**Our Case Number:** ABP-316178-23

**Re:** Proposed development of Oweninny Wind Farm Phase 3 consisting of 18 wind turbines.  
Within the townlands of Laghtanvack, Croaghaun (also known as Croaghaun West), Moneynieran,  
Corvoderry, Shanvolahan, Dooleg More, Shranakilly, Bellacorrick and Shanvodinnaun, Co. Mayo

**Planning Ref: ABP-316178-23**

**Proposed Development:** SID application for Oweninny Windfarm Phase 3 at Bellacorick, Co. Mayo.

ZTV (Zone of Theoretical Visibility) indicating the areas that have a potential view of the proposed turbines at Oweninny Phase III Wind Farm (Tip Height 200m)

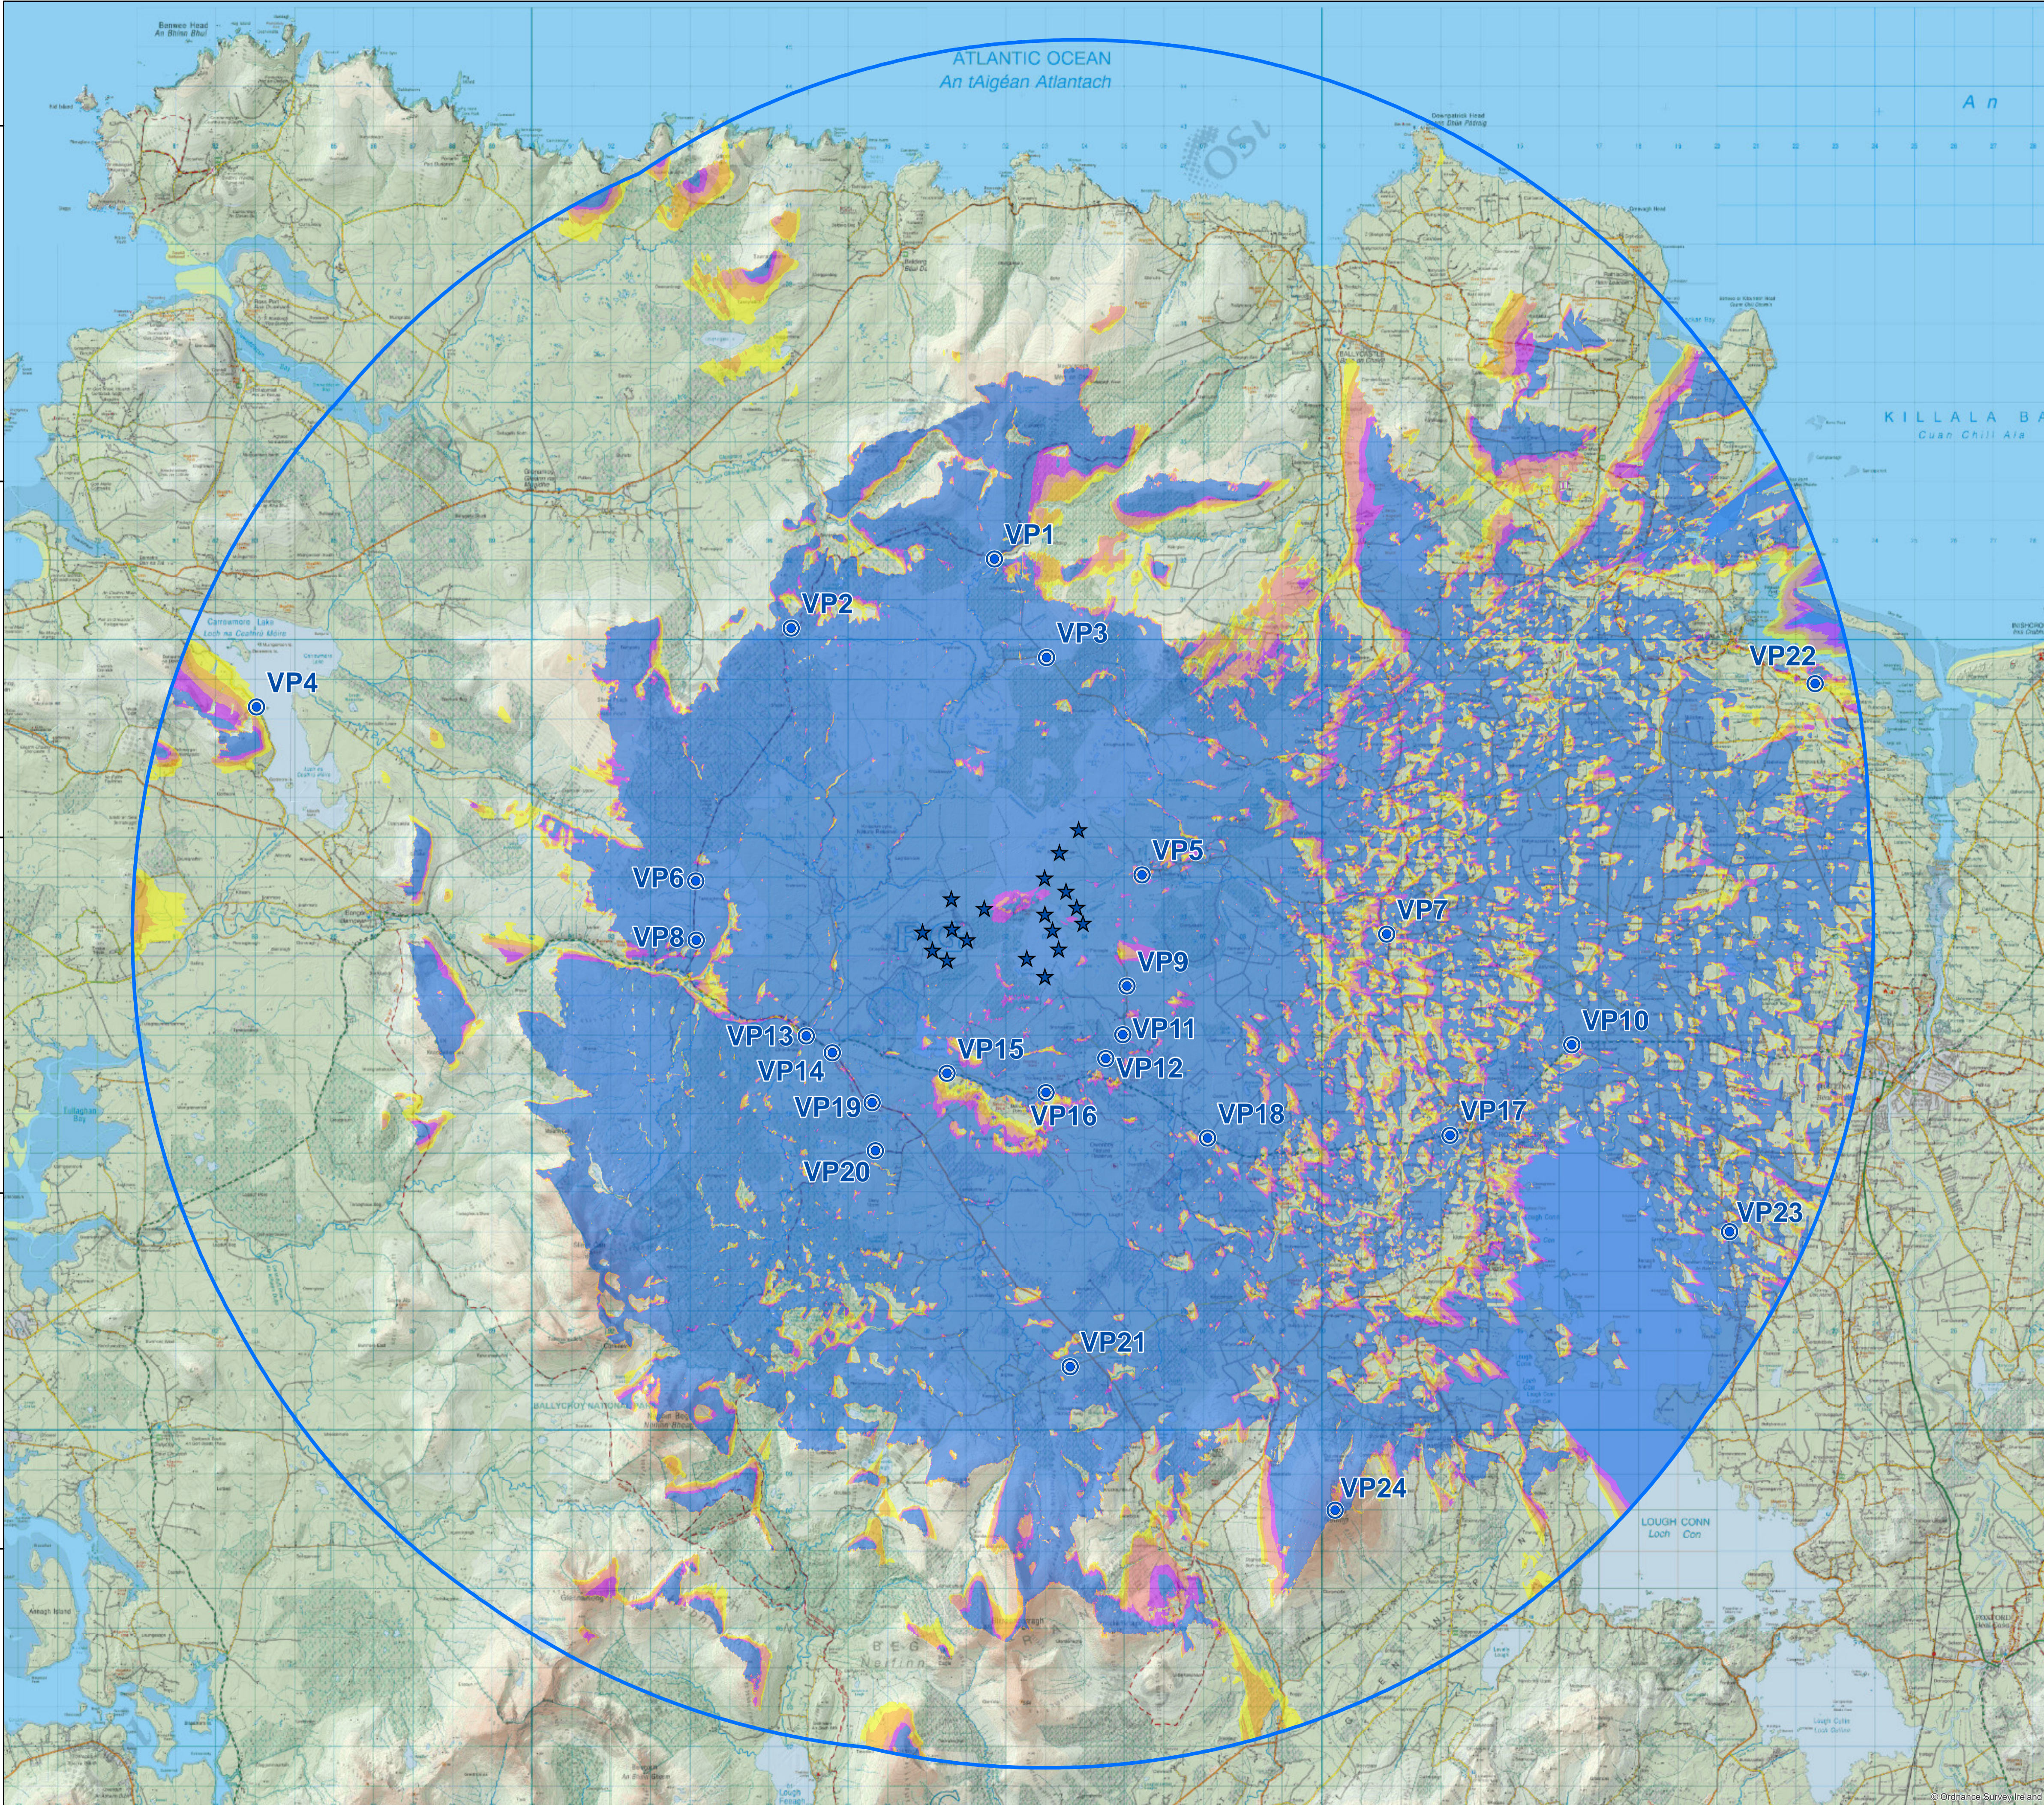
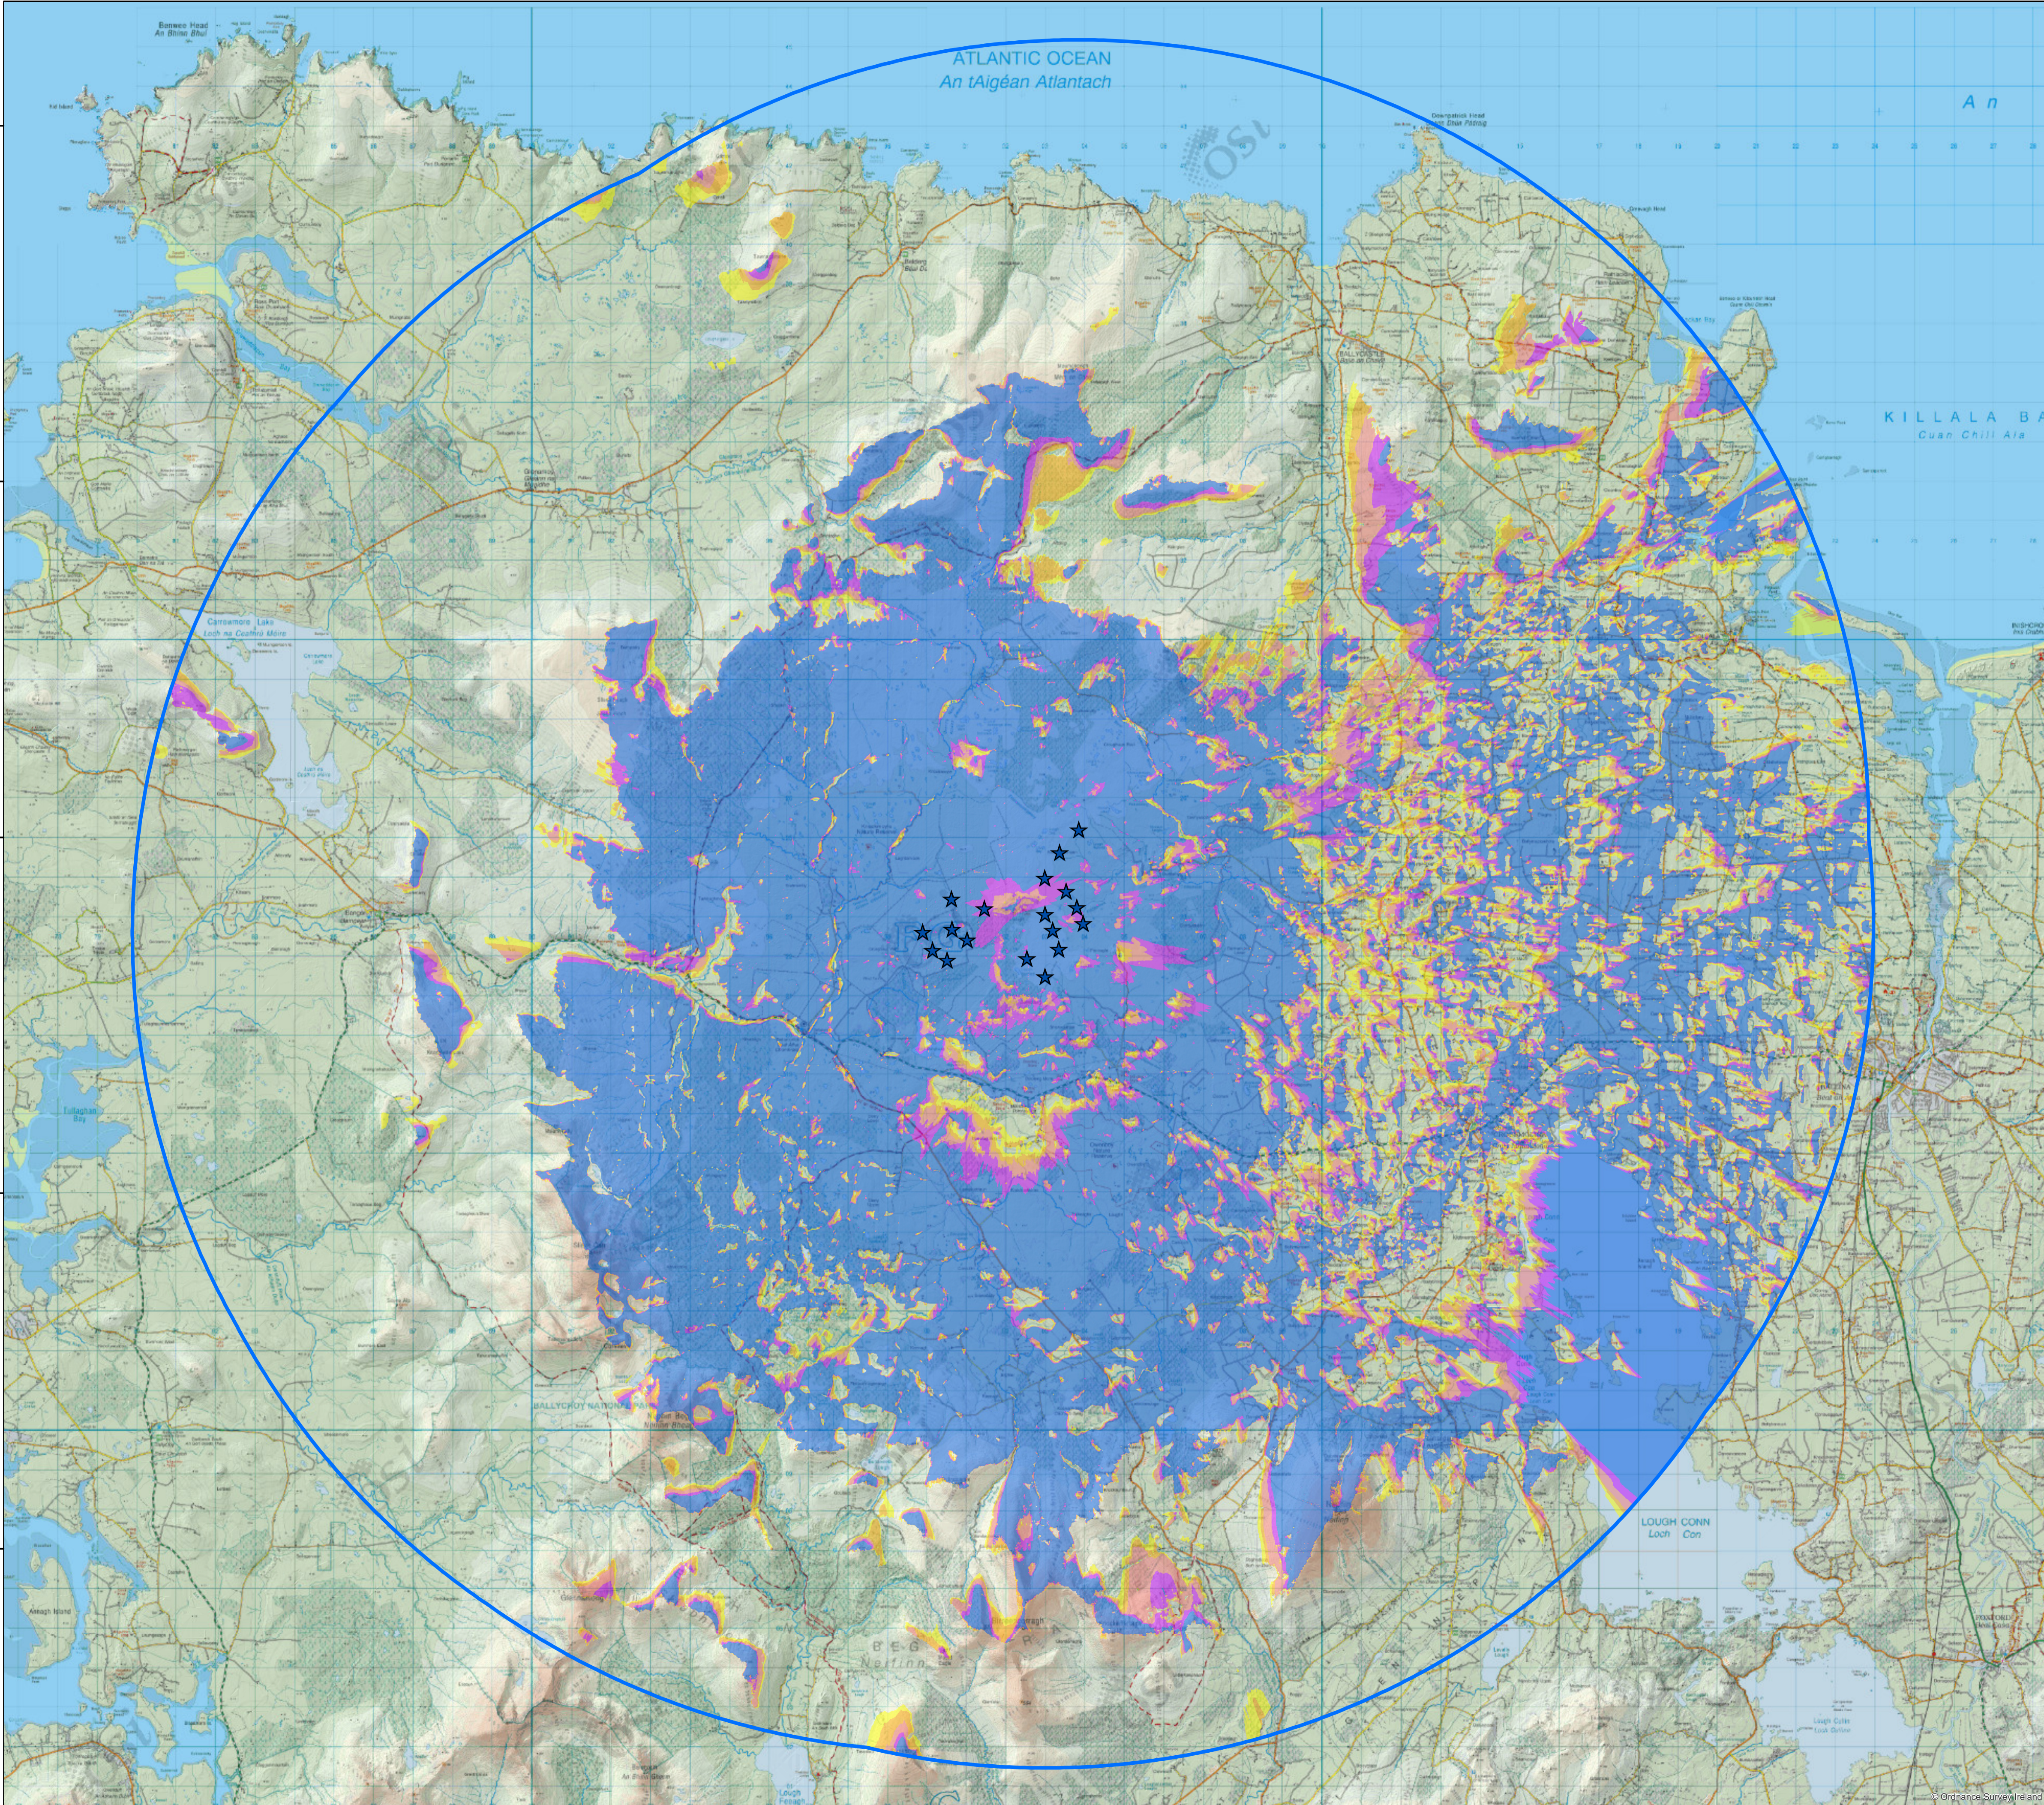
potential indirect impacts (or impacts to setting). On that basis potential impacts to setting were only evaluated for seven Recorded Monuments. The ZTV drawings (EIAR Appendices 15.1 and 15.3) indicate potential visibility for all proposed turbines extends across an area extending 5-10km out from the redline boundary. While acknowledging that ZTV analysis does not include many screening factors such as existing buildings or landscape planting, the stark contrast between the limited study area for the archaeological and cultural heritage environmental baseline and that potential extent of the area where impacts to setting vulnerable receptors (i.e. visual impacts) could occur is concerning. An EIA for a scheme of this type must include an adequate assessment of the possible effects of the proposal on the wider archaeological landscape. It is of importance, therefore, that the study area should be of sufficient size and extent to support this.
